Project Name: RAYNOLDS ADDITION

**CITY OF ALBUQUERQUE
PLANNING DEPARTMENT
September 24, 2014
DRB Comments**

PROJECT # 1010230

RE: Lots 21 & 22, Block 16, Raynolds Addition

SUBDIVISION PLAT OF
LOT 21-A
BEING A RE-PLAT OF LOTS 21 & 22
BLOCK 16, RAYNOLDS ADDITION
PROJECTED SECTION 20, T 10 N, R 3 E, N.M.P.M.
TOWN OF ALBUQUERQUE GRANT
ALBUQUERQUE, BERNALILLO COUNTY, NEW MEXICO
SEPTEMBER, 2014

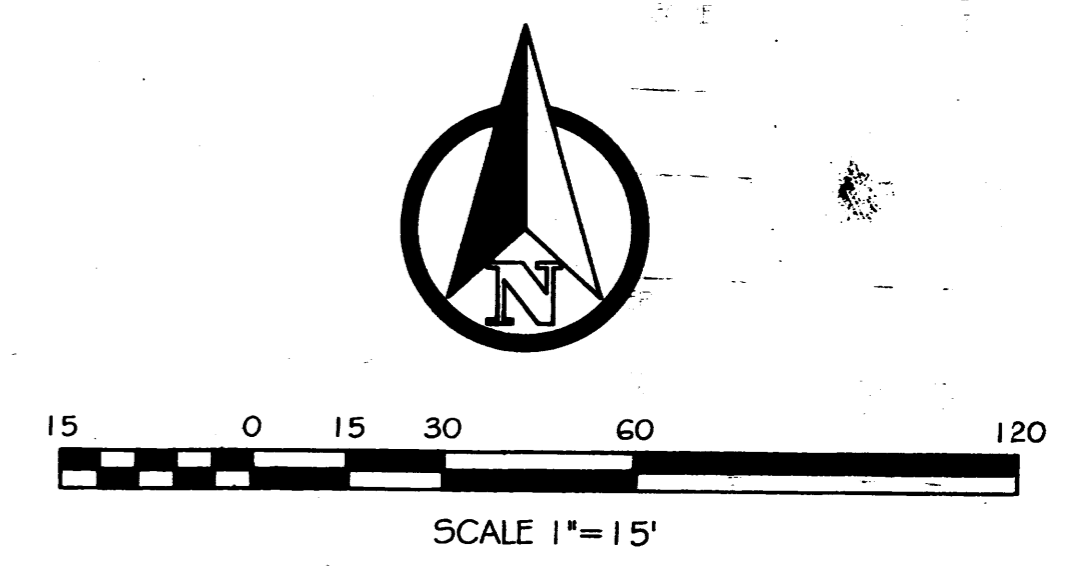
The Location Map is illegible; please provide a vicinity map that identifies the site and nearby streets.
